Yorkshire Water Services
Developer Services
Sewerage Technical Team
PO BOX 52
Bradford
BD3 7AY

19th March 2025

**Former Royston Working mens club, 52 Church Street, Royston, Barnsley S71 4QU -
Pre-Planning Sewerage Enquiry V819620**

Dwg No. : STE/25/06/01
Date : 26-3-25
Scale : 1:200

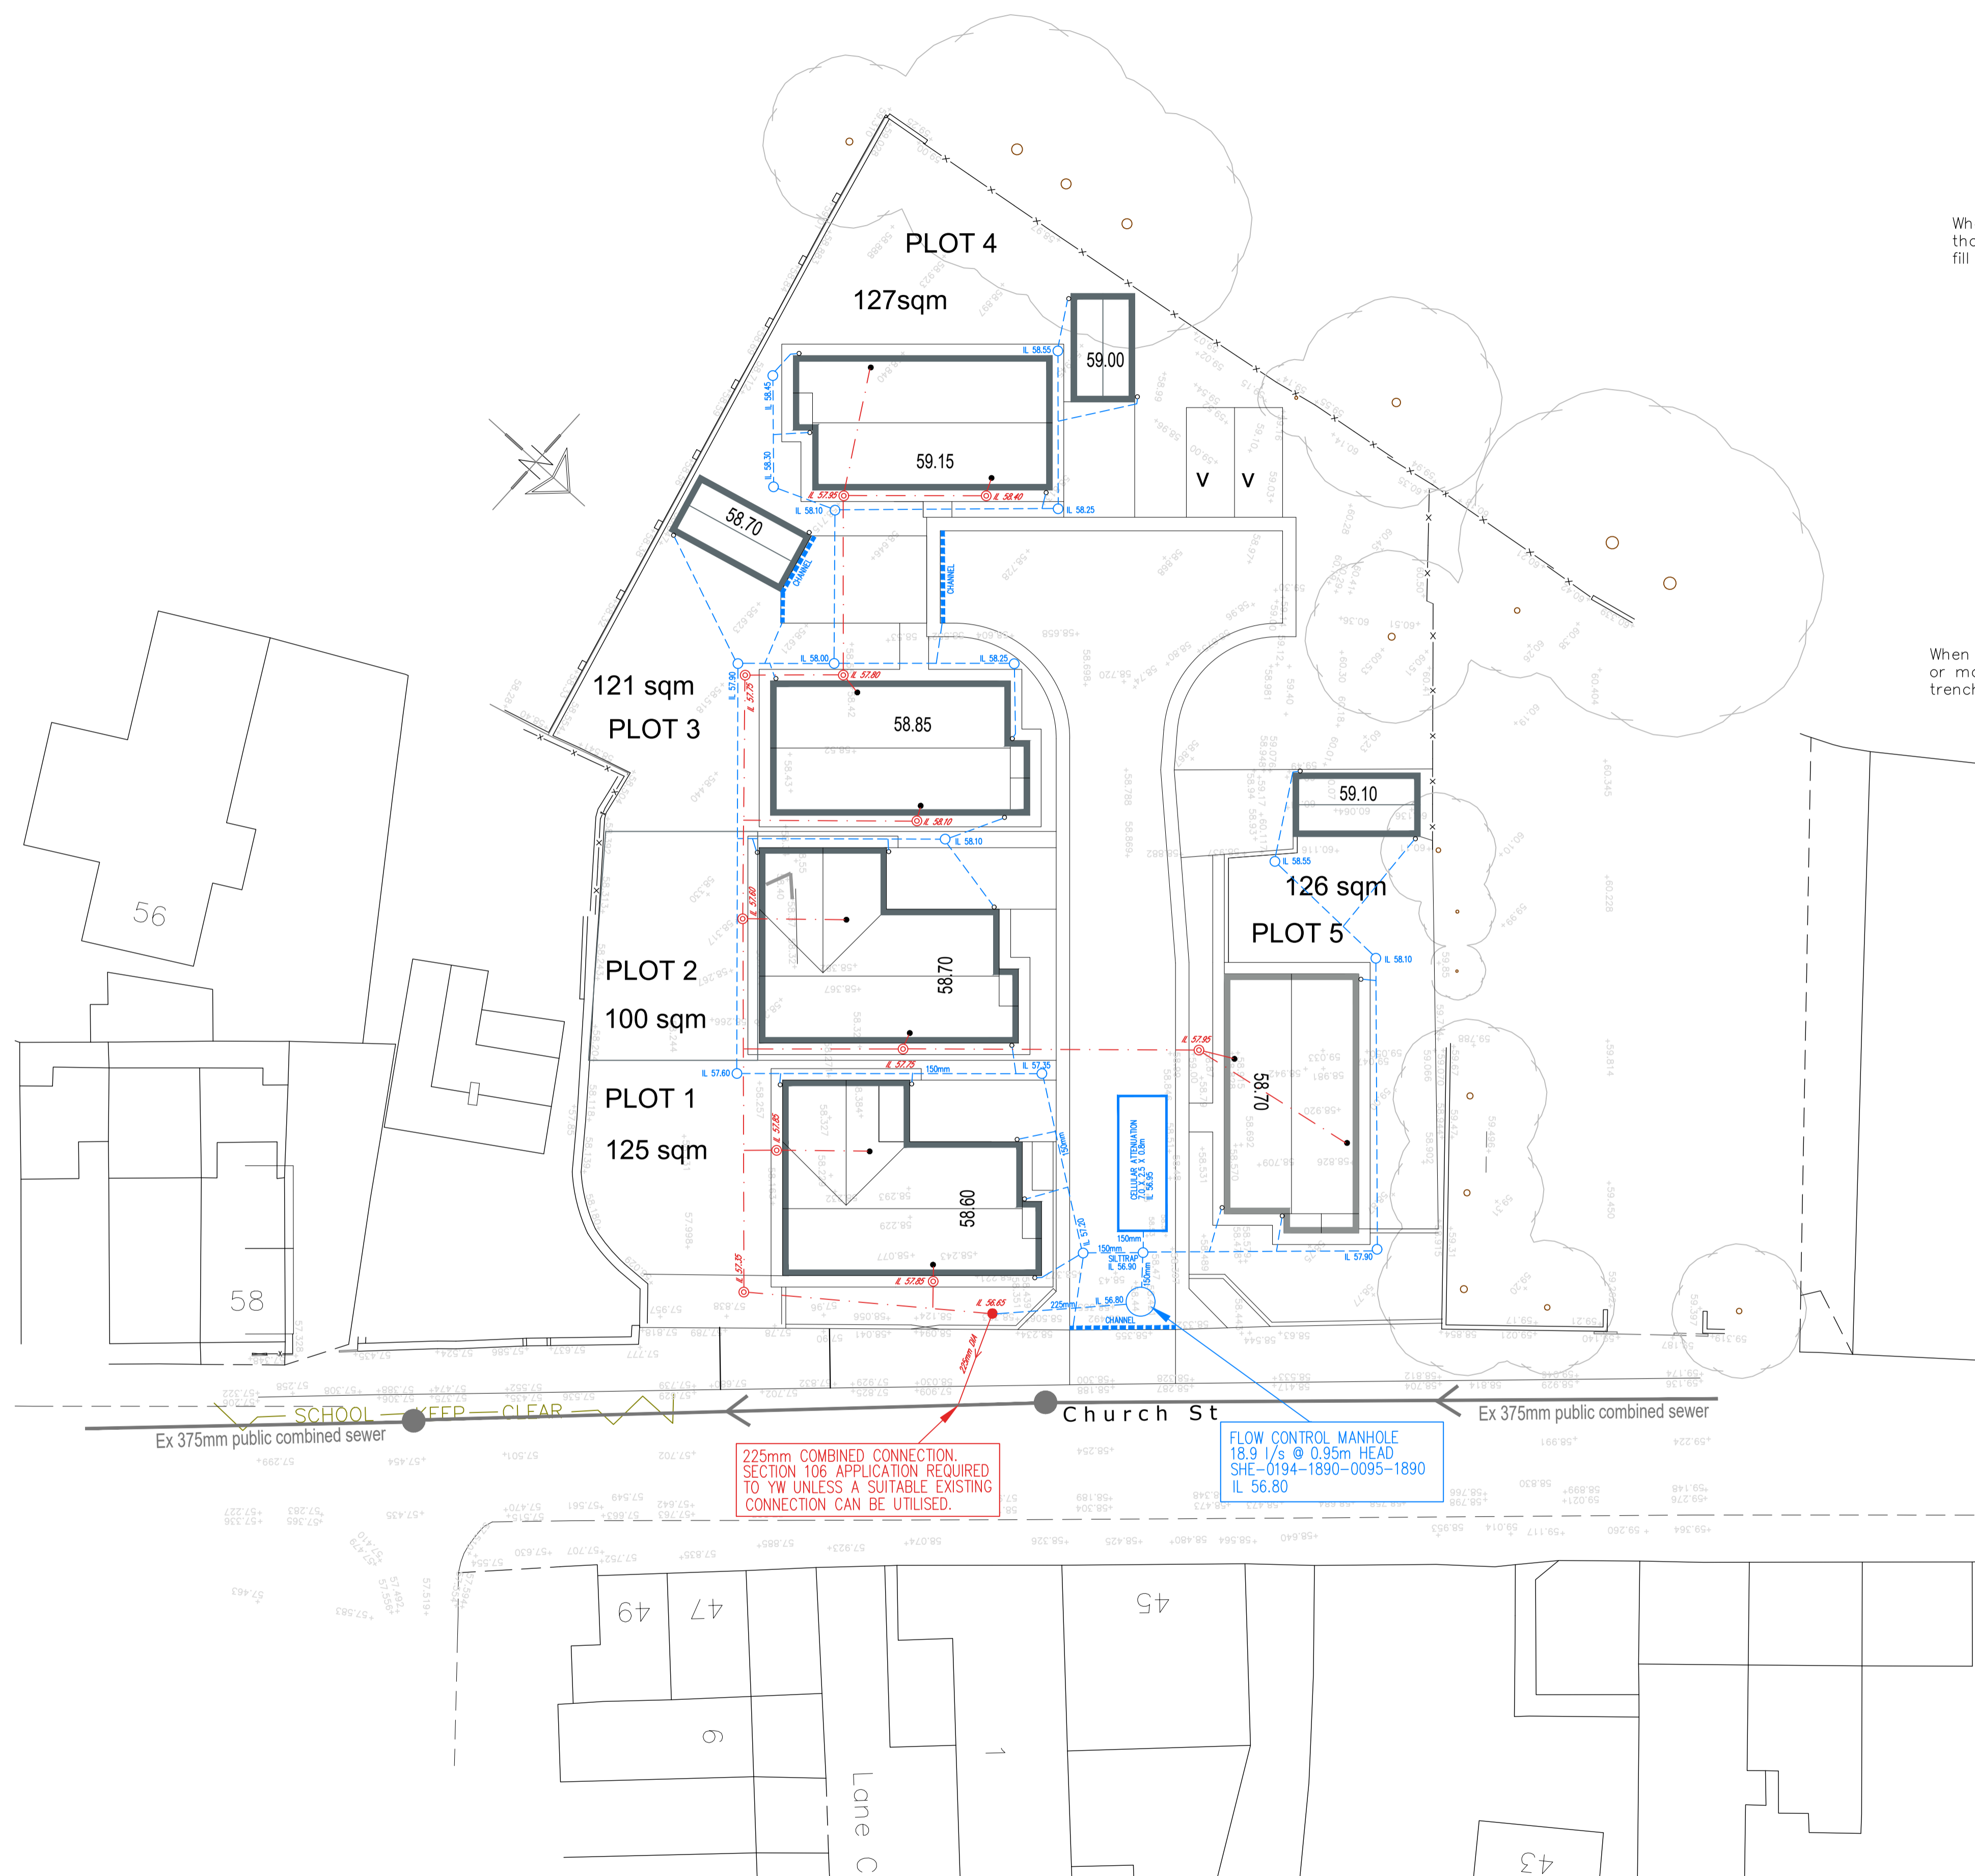
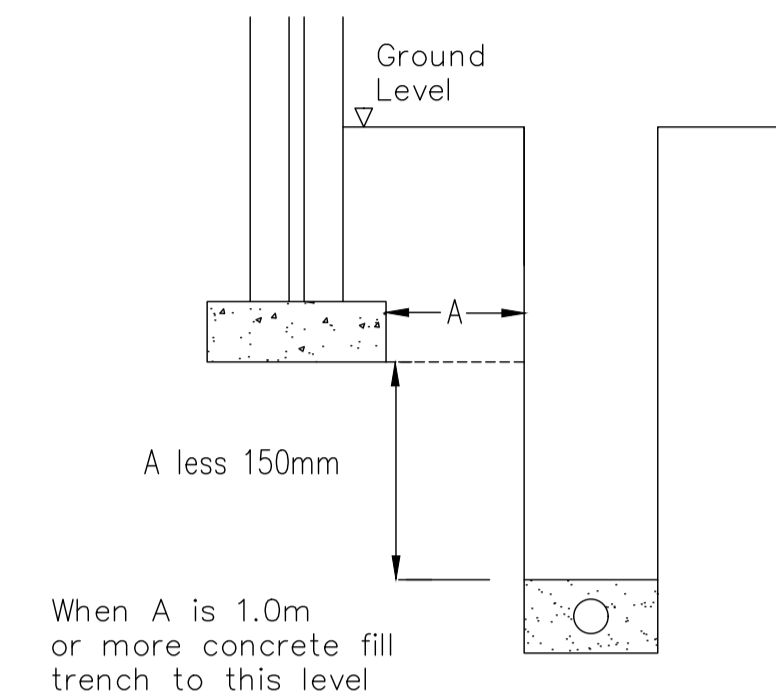
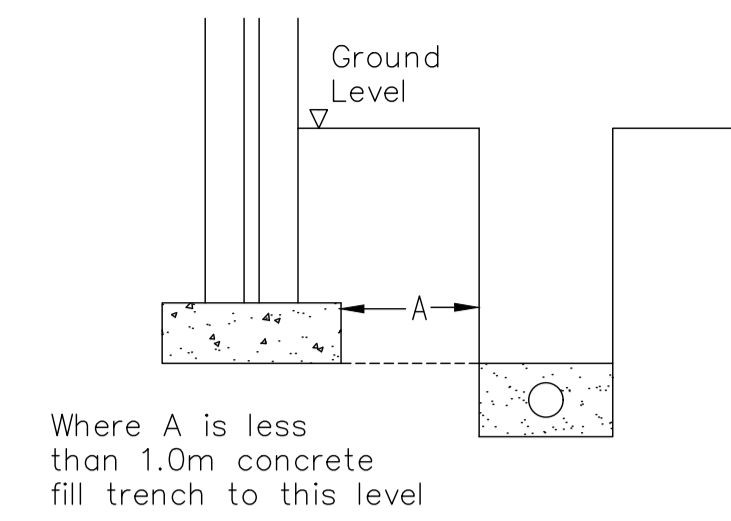
Foul water domestic waste can discharge to the 375 mm diameter public combined sewer recorded in Church Street.

There is a highway drain on Church street that may prove a suitable means of surface water disposal - Connection subject to approval from the highways authority.

As a last resort and subject to providing satisfactory evidence as to why the other methods of surface water disposal have been discounted, curtilage surface water may discharge to the to the 375 mm diameter public combined sewer recorded in Church Street, at a restricted rate not to exceed 18.9 litres per second.
